Rezoning Transportation Analysis

Petition Number: #2022-070

Date	Description
09-29-22	First Review (PDM)
10-27-22	Second Review (TM)

Liberty Crossing Mixed-Use Rezoning Site Plan

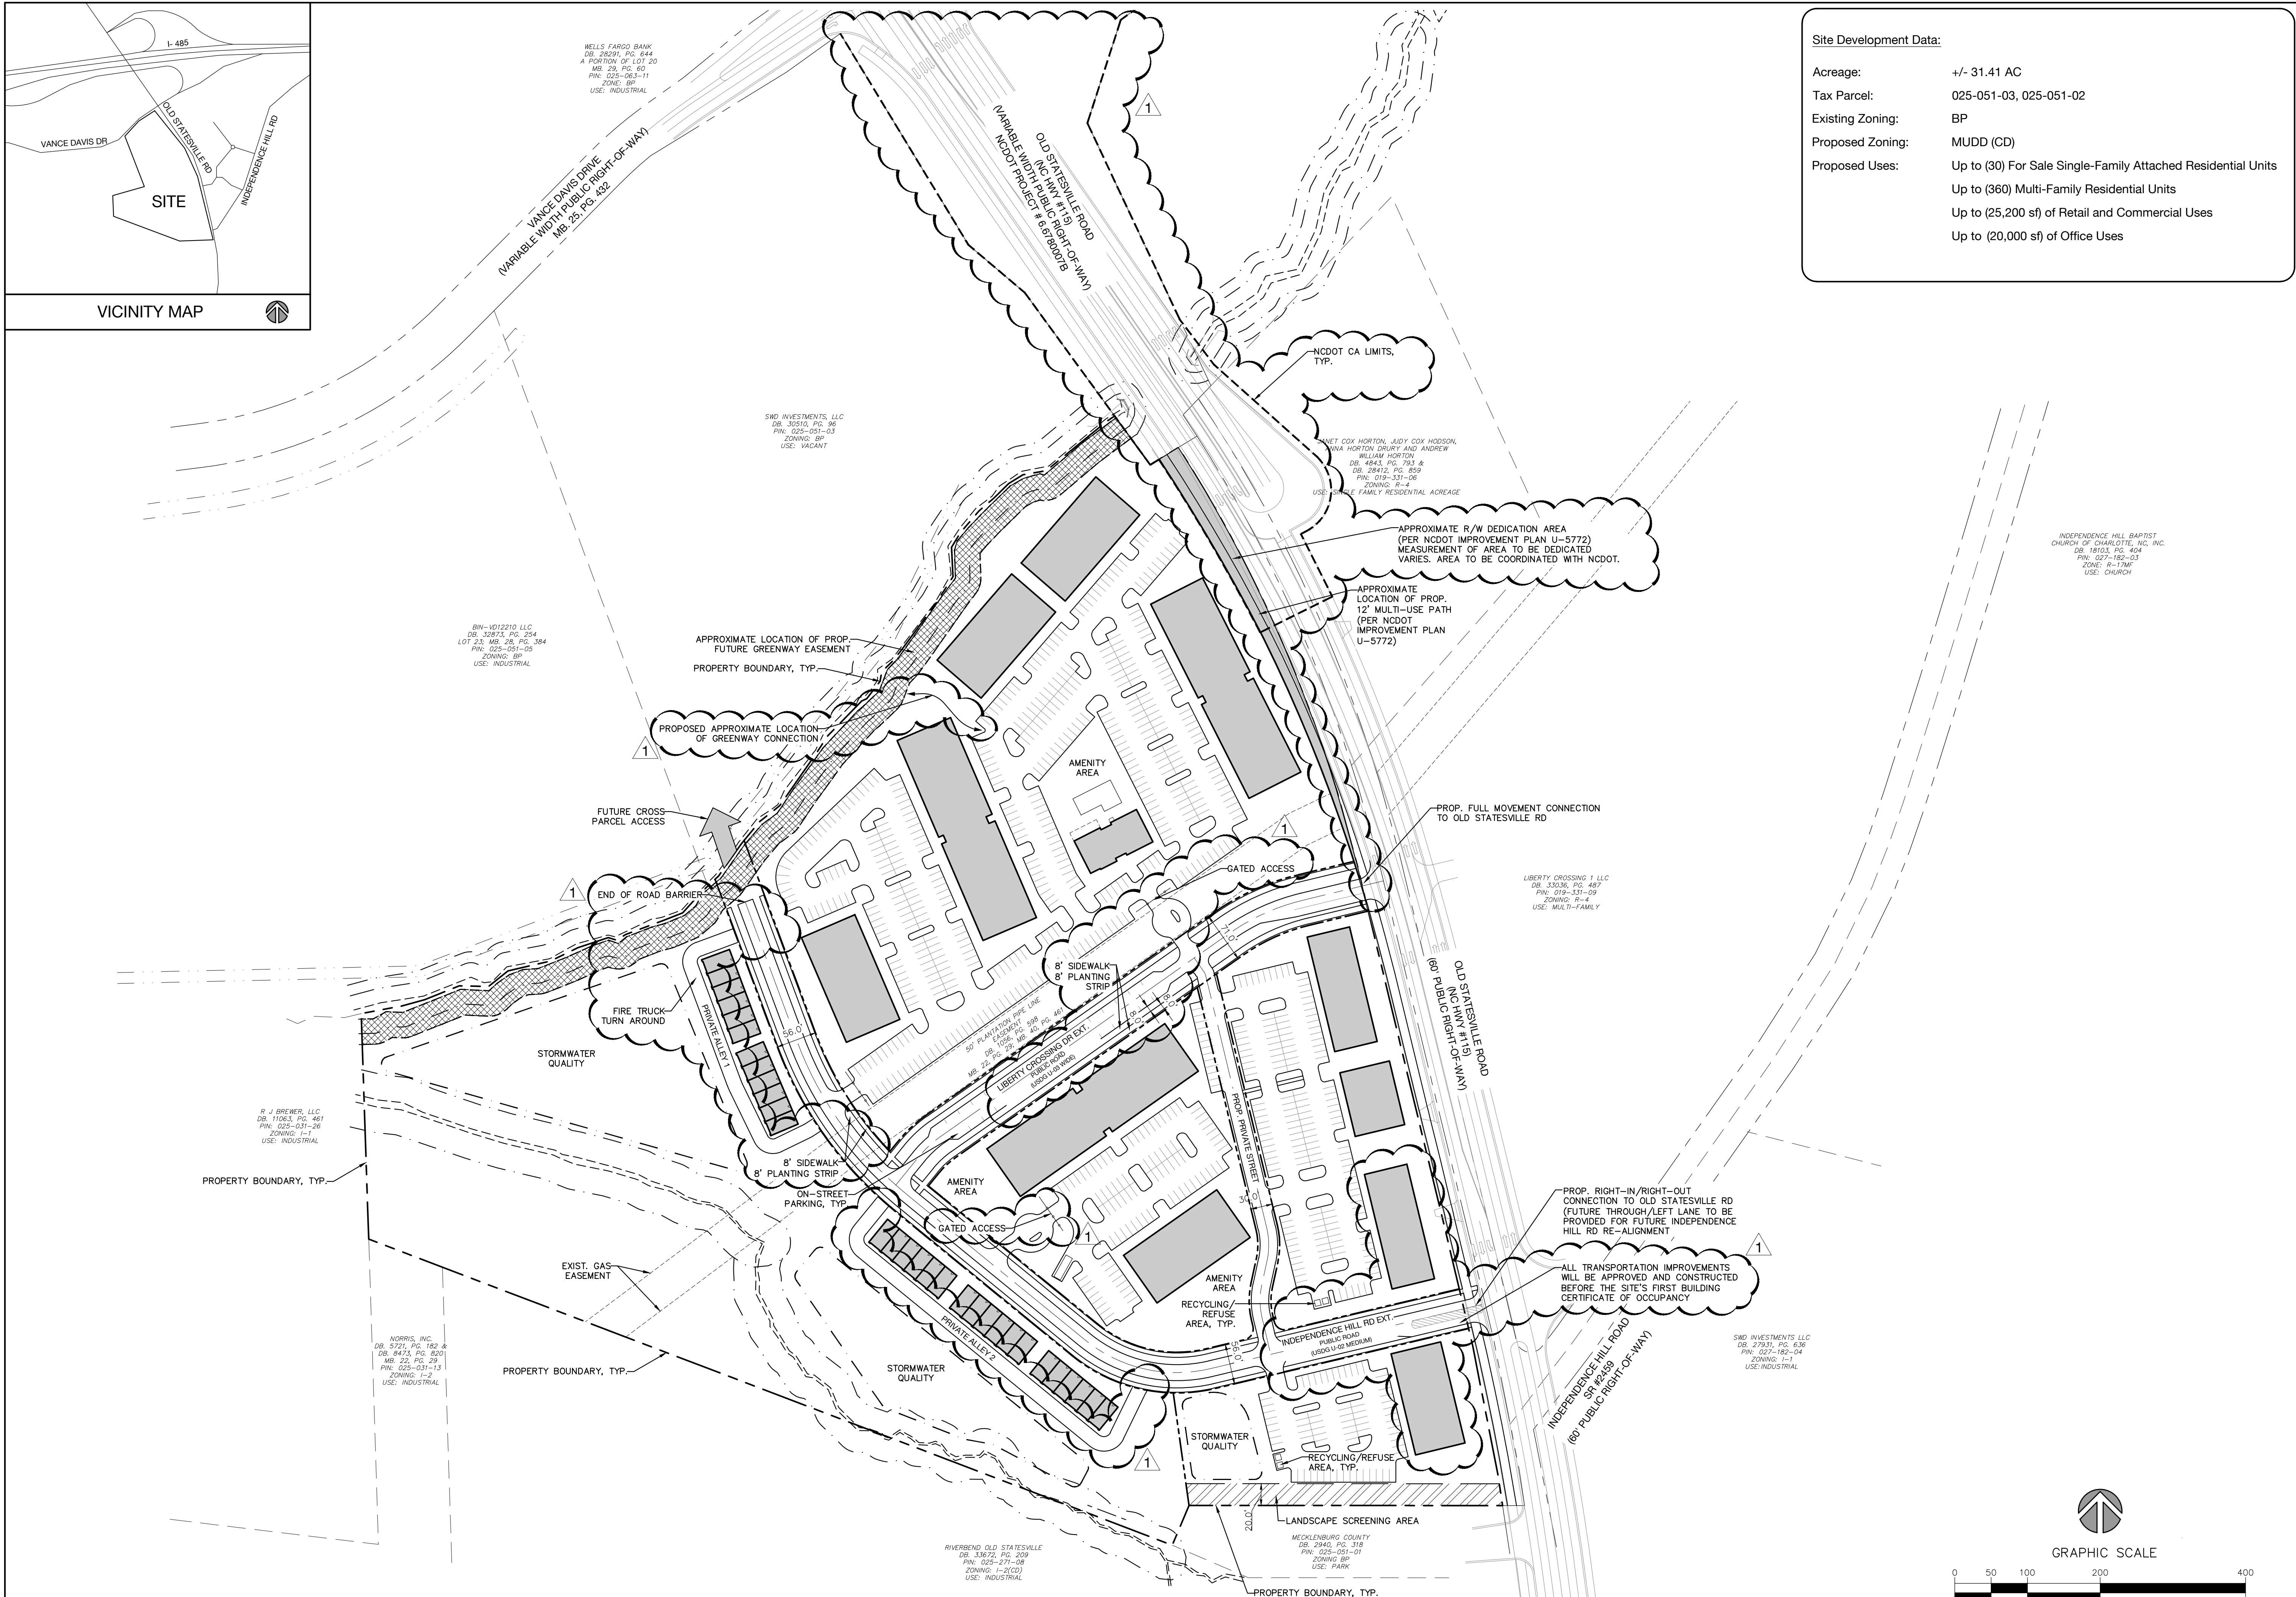
1. **Curbline:** The proposed zoning district has a setback measured from back of the existing or proposed future curbline.
 - a. **Old Statesville Road:** The future location of the back of curb and gutter shall be located at minimum 36-feet from the centerline of the roadway.

Outstanding Comment From 9-29-22: Label and dimension the curb and gutter from the centerline for each road on the site plan.

3. Revise site plan to dimension the proposed right-of-way along Old Statesville Road to be dedicated. The ROW dedication shall include the necessary widths to accommodate the NCDOT U-5772 project.

Clarifying Comment (10-26-2022): Dimension ROW along Old Statesville Road from the centerline of the roadway.
